Application for Removal or Variation of a Condition following Grant of Planning Permission or
Listed Building Consent

Number	<input type="text" value="322"/>
Suffix	<input type="text" value="A"/>
Property Name	<input type="text"/>
Address Line 1	<input type="text" value="St Albans Road"/>
Address Line 2	<input type="text"/>
Address Line 3	<input type="text" value="Hertfordshire"/>
Town/city	<input type="text" value="Watford"/>
Postcode	<input type="text" value="WD24 6PQ"/>

Erection of side and rear extension, alterations to existing elevations and change of use of rear part of ground floor to office (Use Class B1a)

Planning History 18/01188/FUL, then after application for external painted insulated render to gable/side elevation under 19/00223/VAR.
Revised drawings being PL-3000 REV B & PL-4000 REV B for 19/00223/VAR.

**Proposed Elevation C**  
Scale 1:50

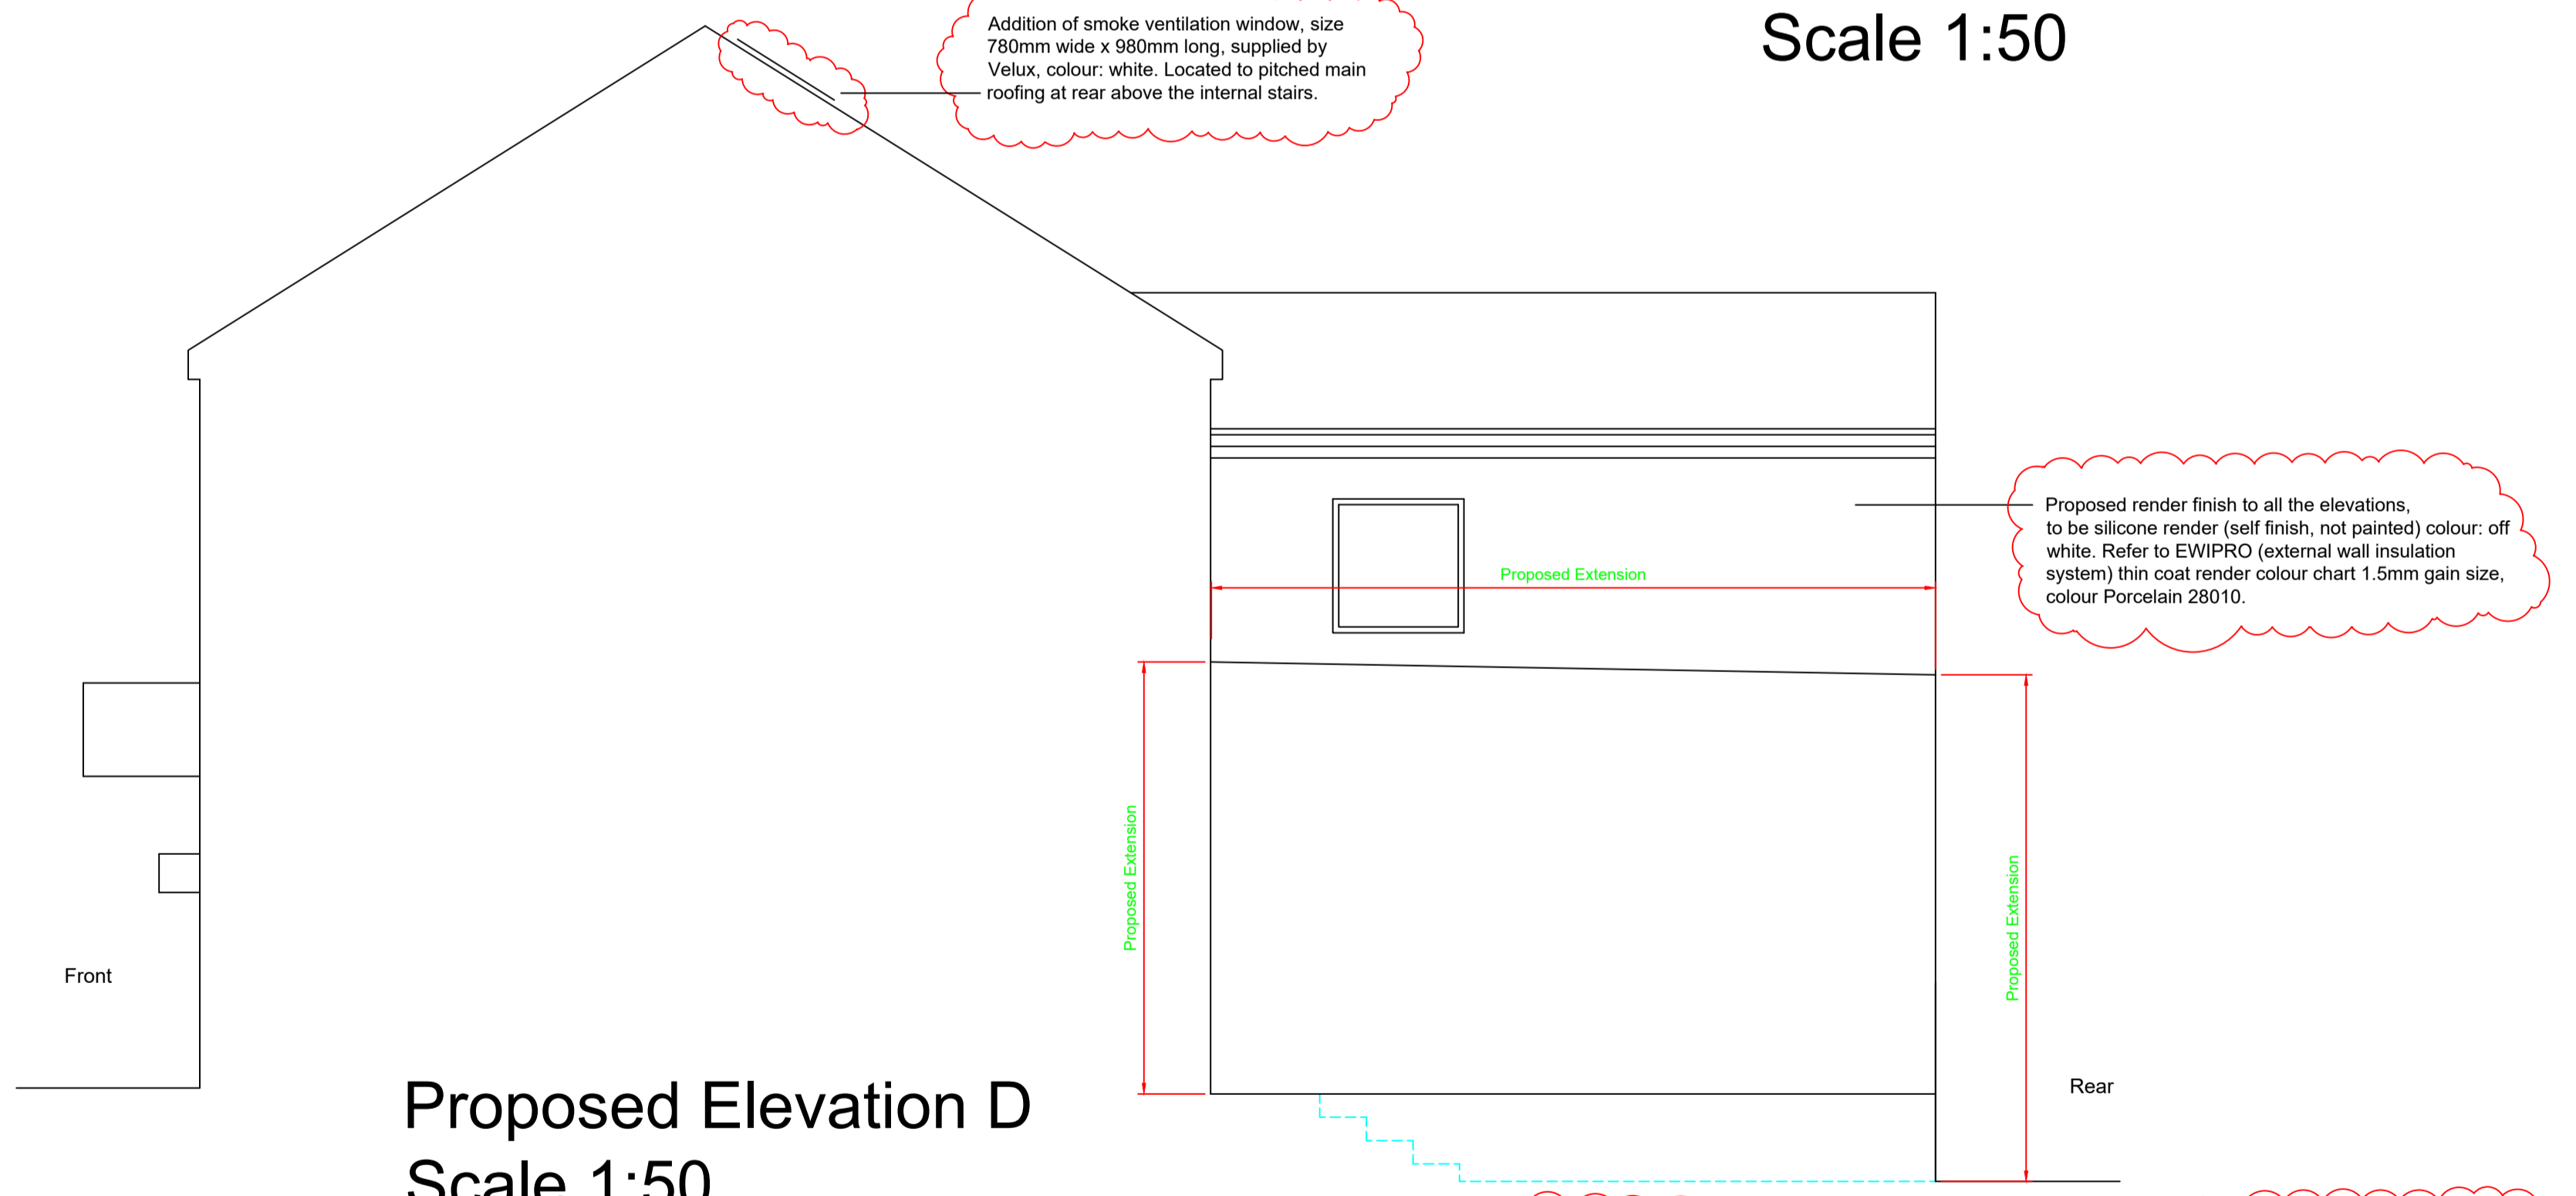
1/ Now this application is for another variation being addition of render finish to all the elevations being the rear, sides and front walls, also render type to be silicone render all the elevations (self finish, not painted) colour: off white. Refer to EWIPRO (external wall insulation system) thin coat render colour chart 1.5mm gain size, colour Porcelain 28010, refer to paper copy submitted and sample. Revised plans submitted PL-3000 REV D & PL-4000 REV D. Note that previous render to gable was painted finish, now silicone self finish Porcelain 28010.

1/ Note that proposed external finish is to match existing building, there would be no adverse effect on the character and appearance of the building or surrounding area.

Proposed Roof Plan Scale 1:50

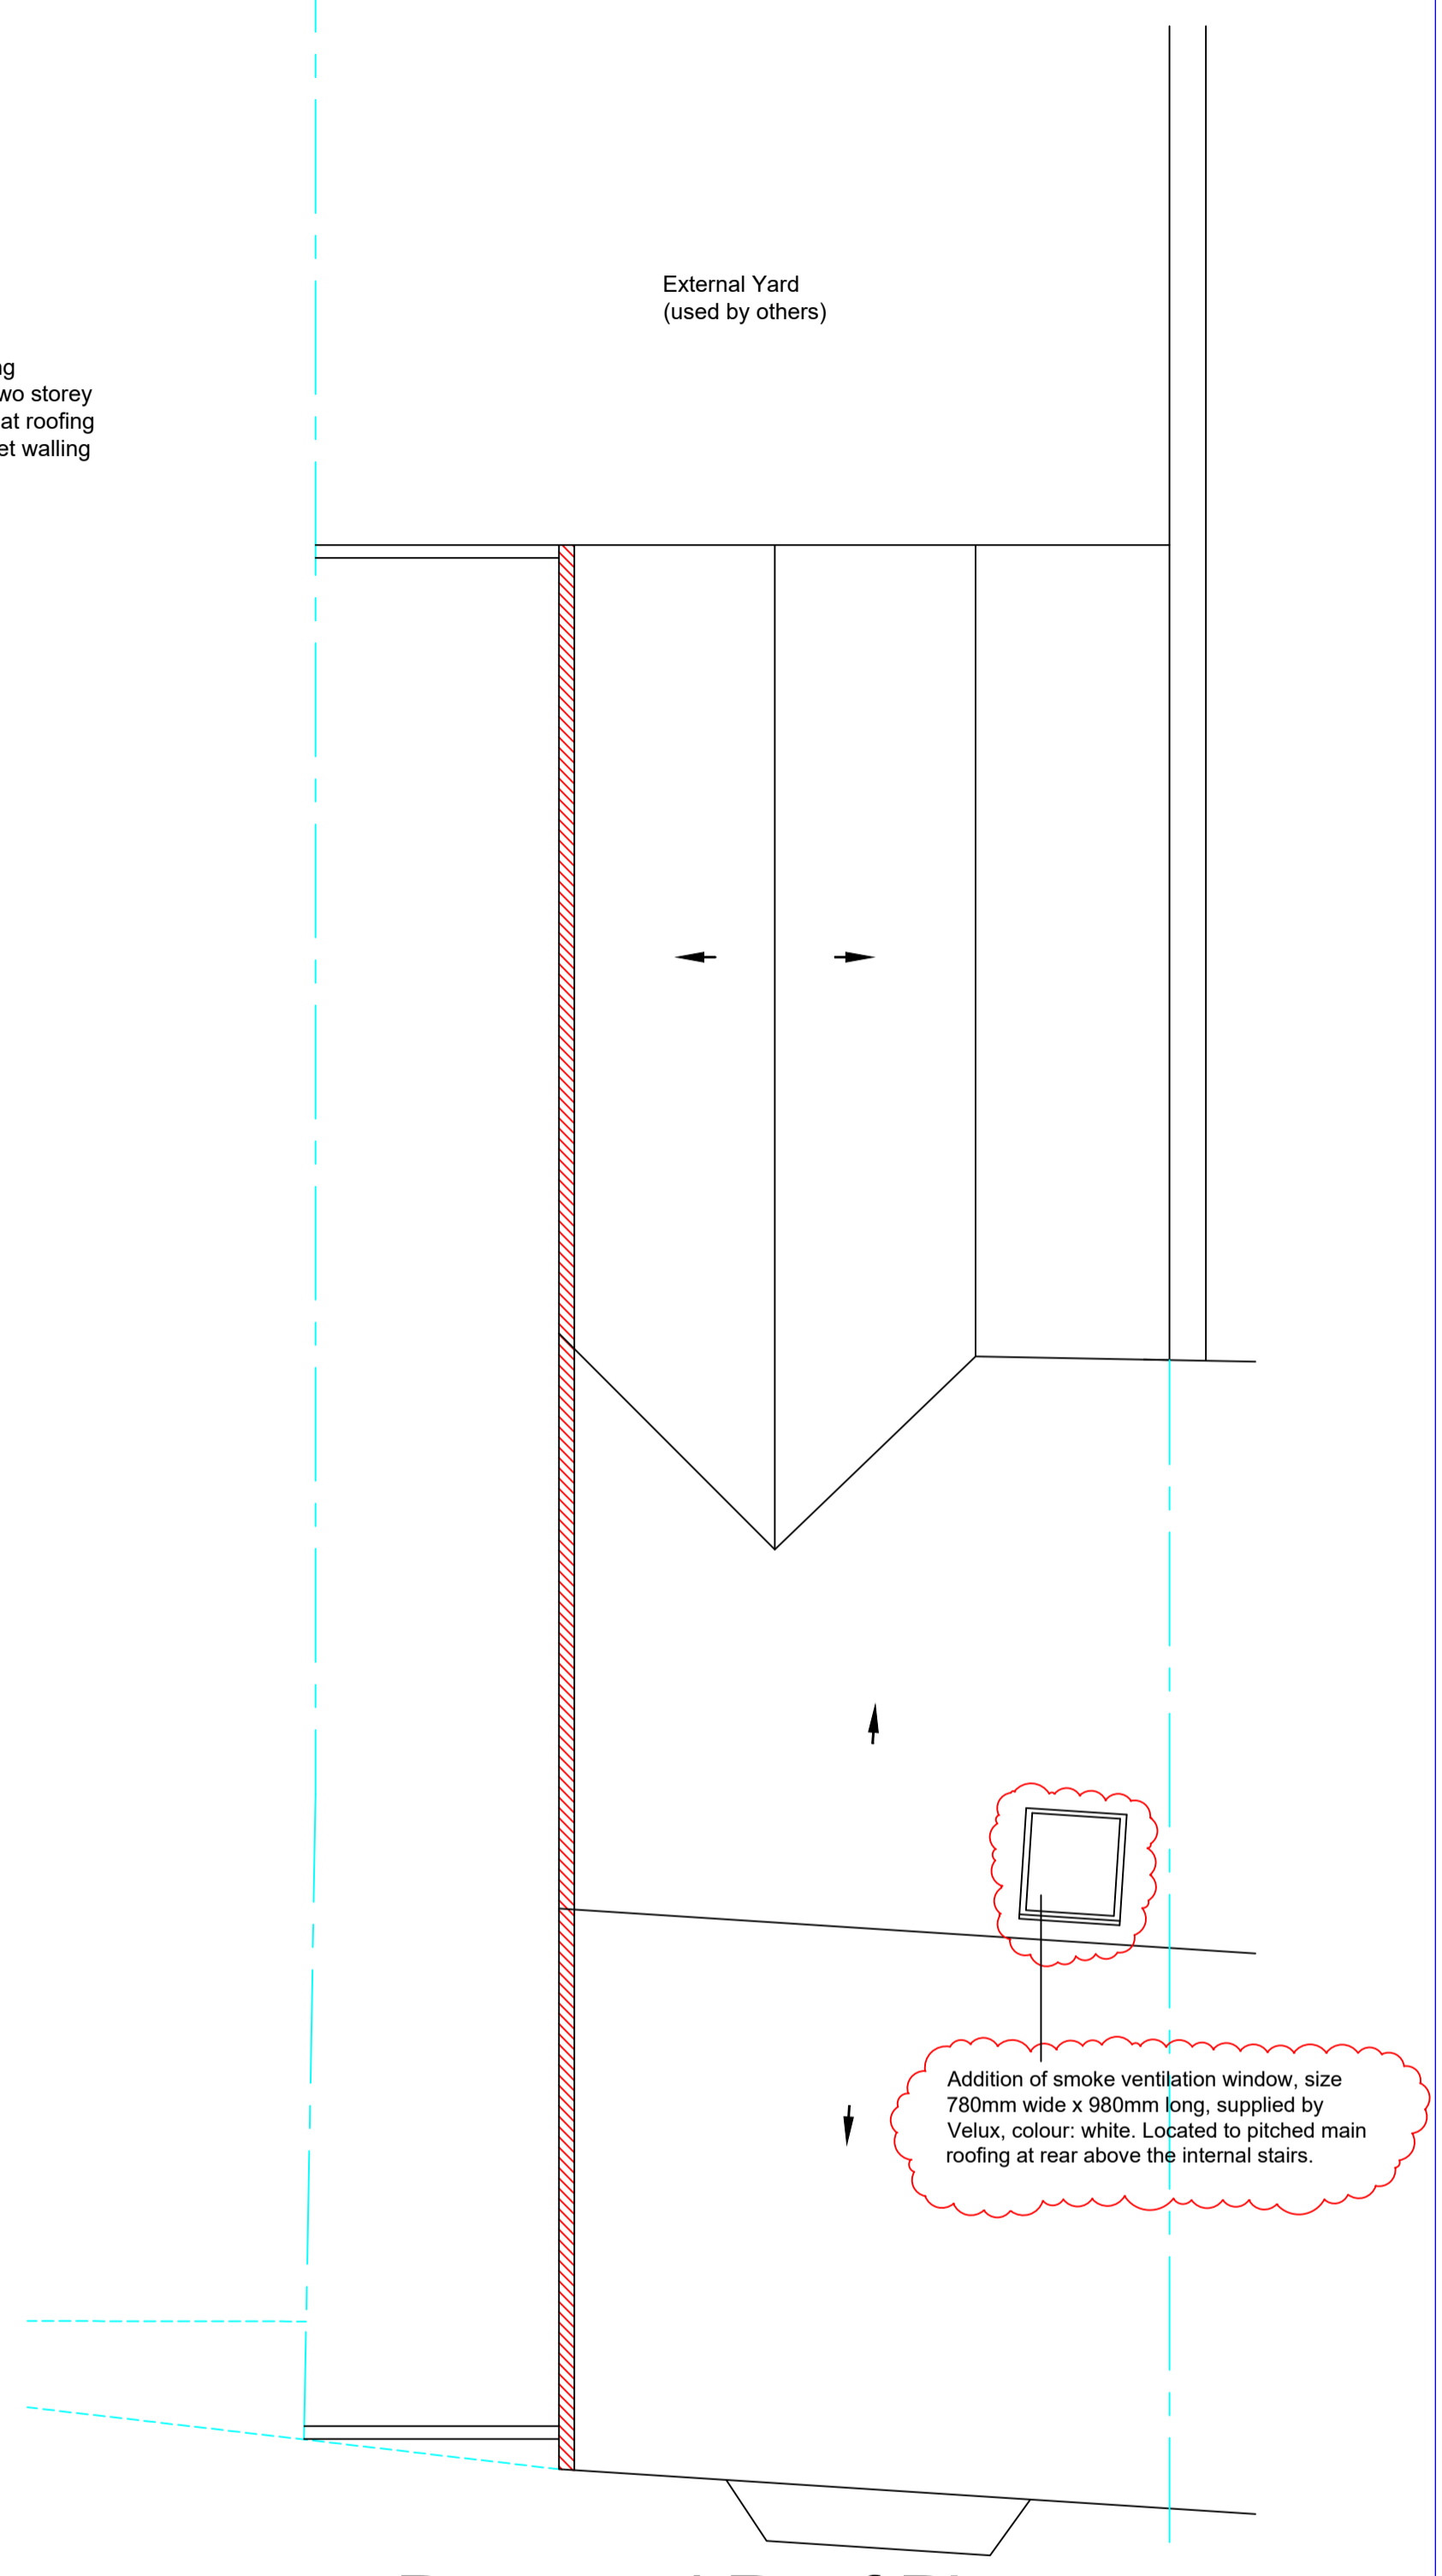
2/ Addition of Smoke Ventilation Window, size 780 mm wide x 980 long mm,
supplied by Velux, colour: white. Located to main roofing rear elevation above internal stairs.

2/ Note that smoke ventilation window, for building regs allows smoke to be vented above the common stairs. No impact on street view.
